Appendix L - The Sandstone Precinct– SSD 6751 MOD 2 and SSD 7484

Response to Government Agency Submissions

Winter Solstice, June 21, 12 Noon

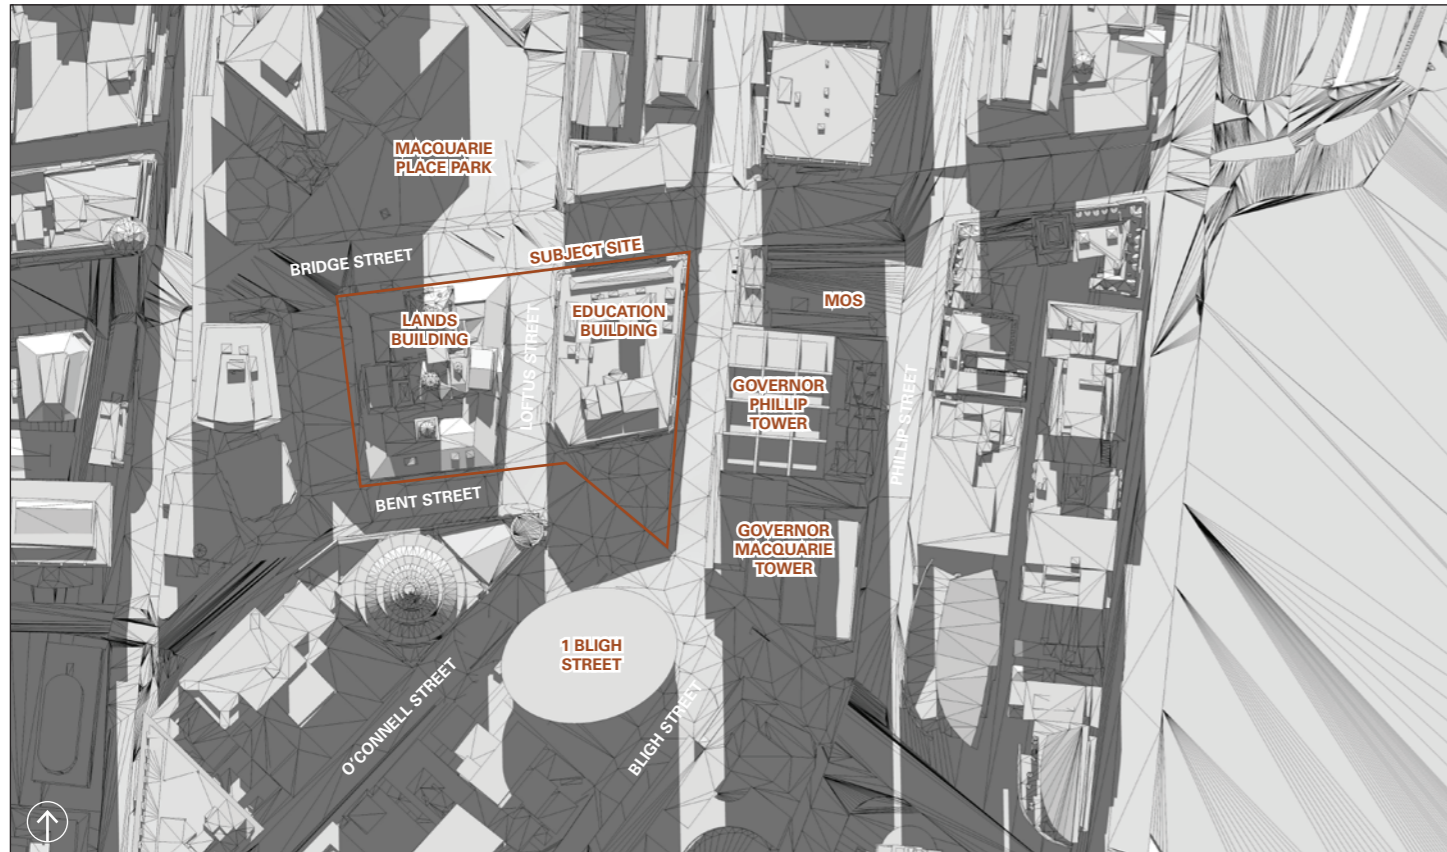
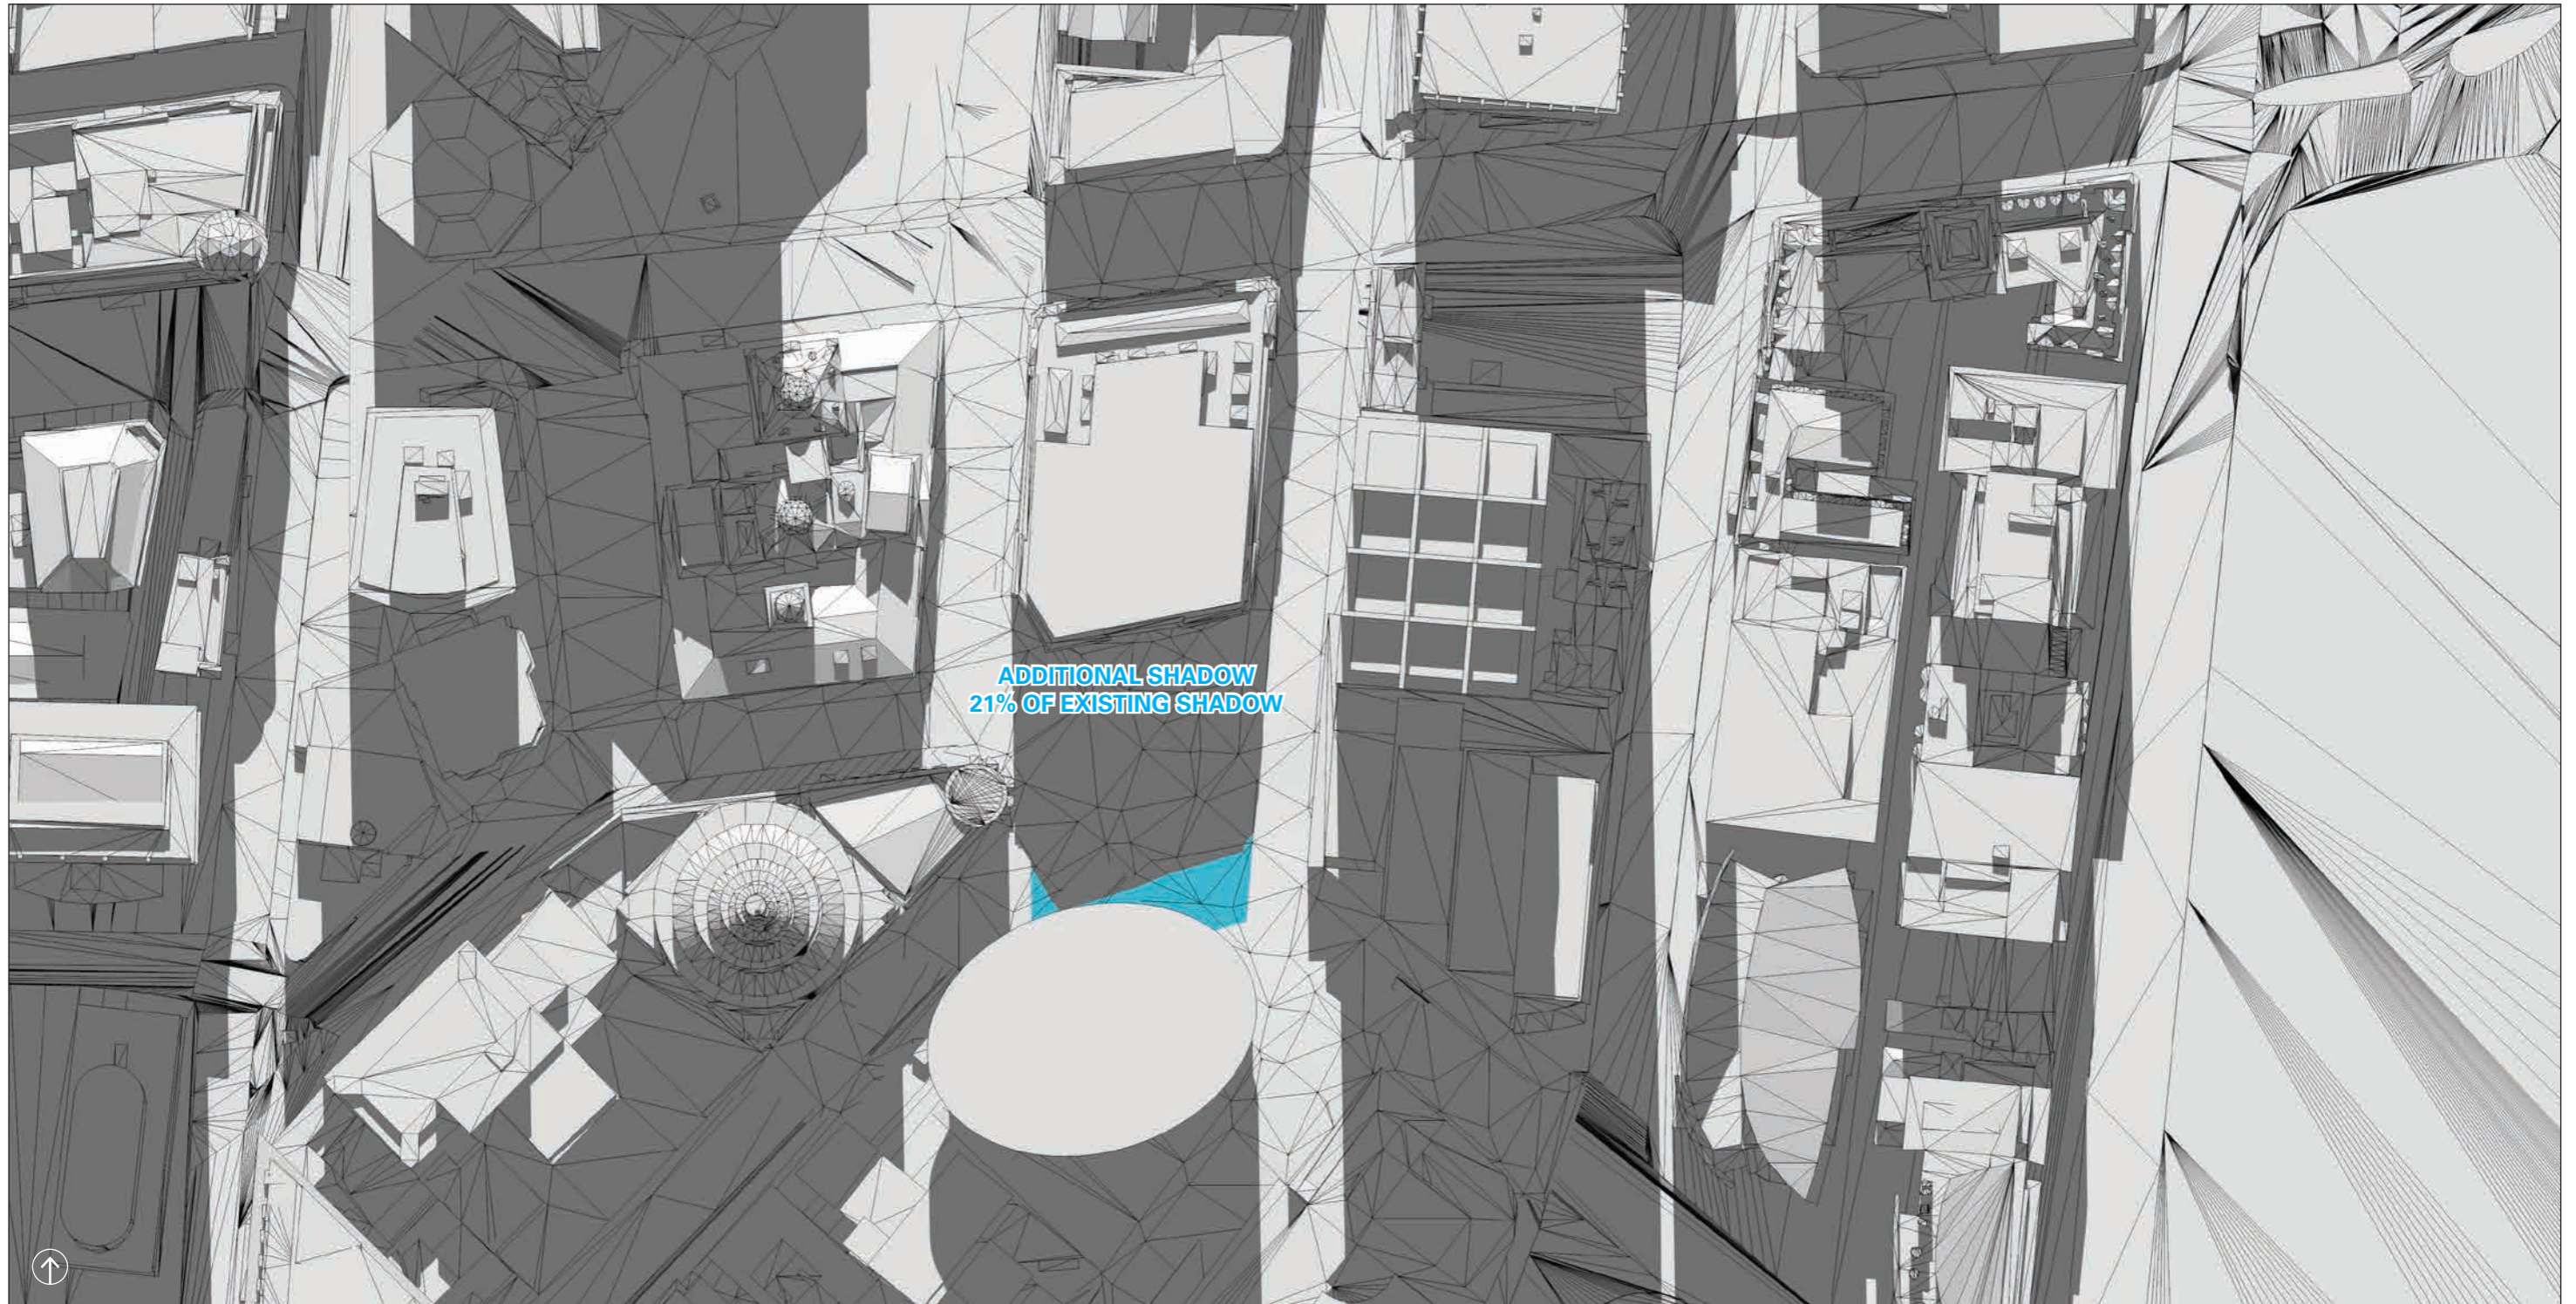
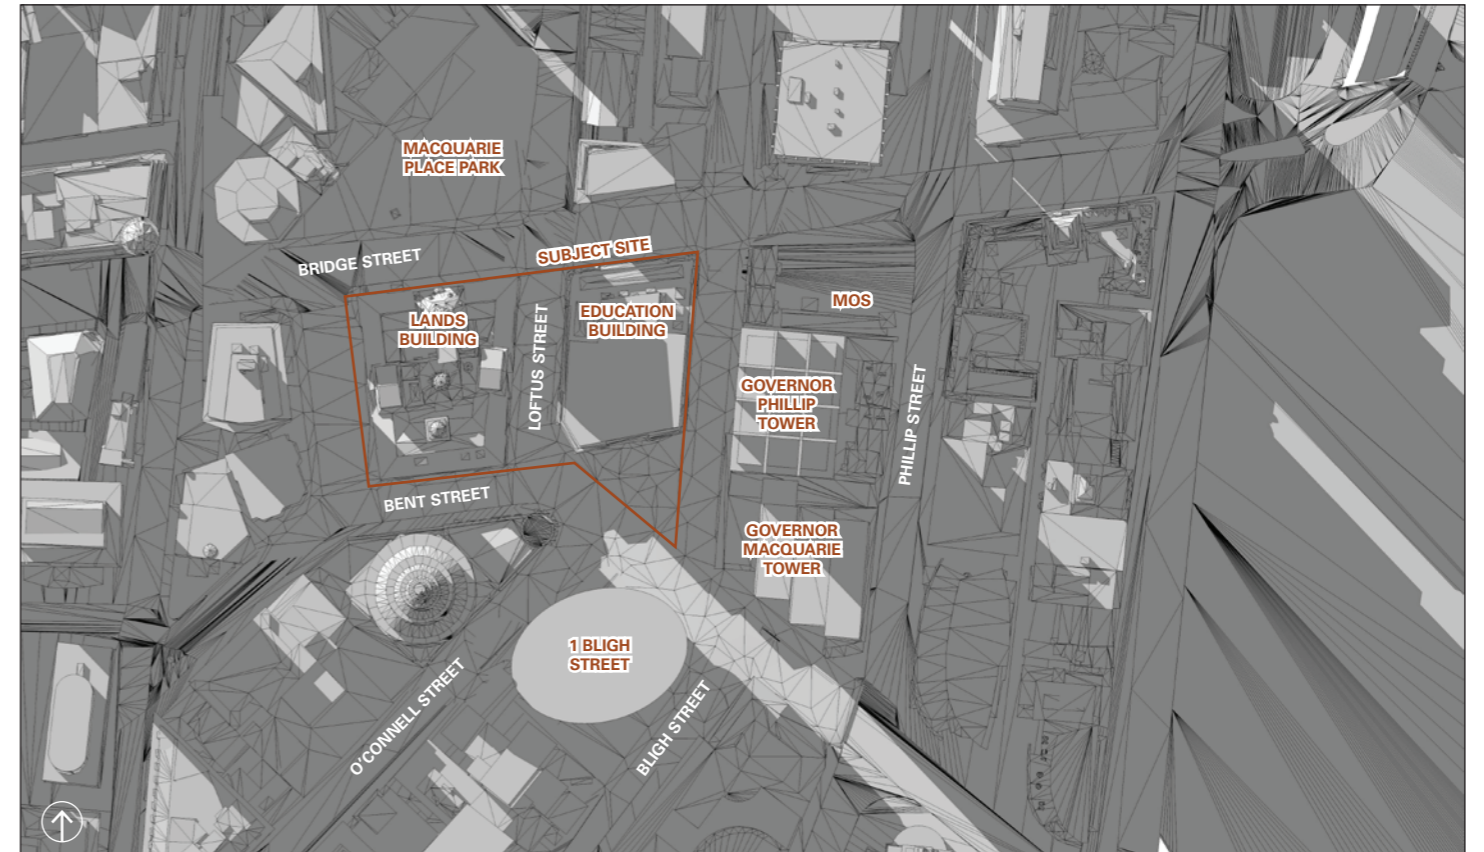
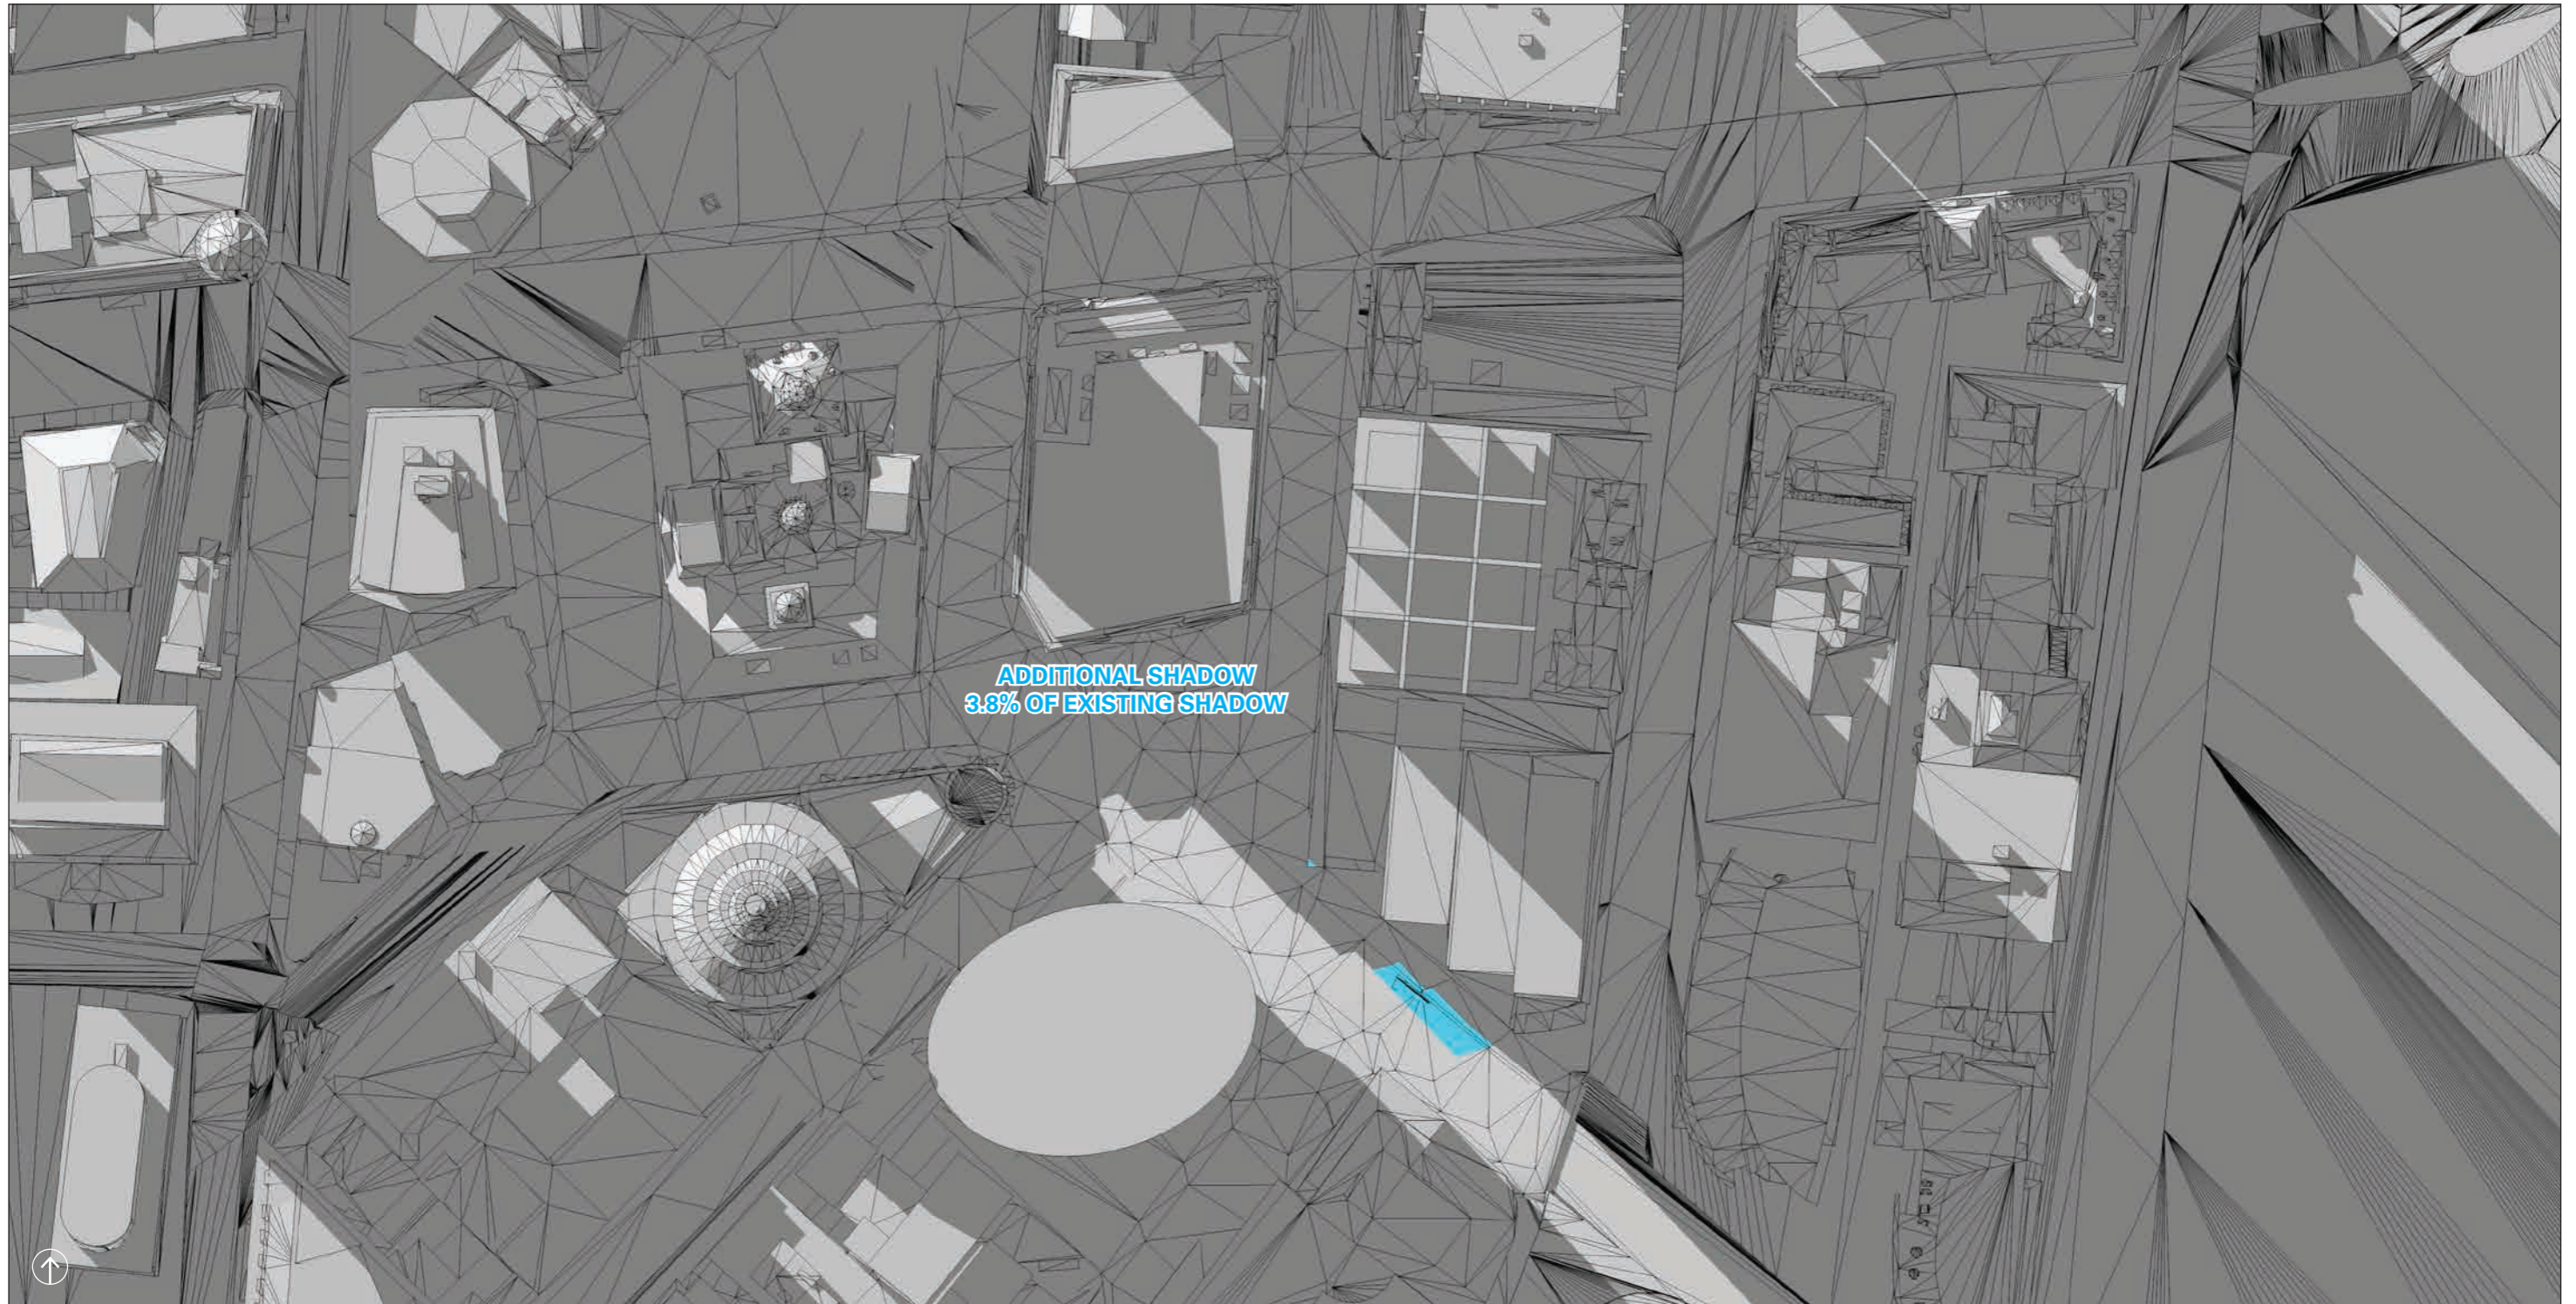
<ul style="list-style-type: none"> Any increase to the roof level of the Education Building would impact upon solar access of Farrer Place and is not supported. 	Additional shadow diagrams have been prepared that demonstrate the shadowing of Farrer Place under Stage 2 is less than that of the approved Stage 1 envelope (Refer to Appendix J).
<ul style="list-style-type: none"> Both the Lands and Education buildings are of State Heritage significance and should be treated accordingly. Lessening the impact on one building only to justify increasing heritage impact on another is not an acceptable heritage outcome. 	Noted. The use of the proposed buildings and roof envelope of the Education Building was approved at Stage 1.
<ul style="list-style-type: none"> The Trust voices its concerns about the potential decrease in public space in Farrer Place through the construction of a new vehicular drop-off leading from Bent Street. 	The reduction of public space by the new drop off will be offset by the increased public space created at the intersection of Loftus Street and Bent Street. The nett result is that Farrer Place will remain the same size.
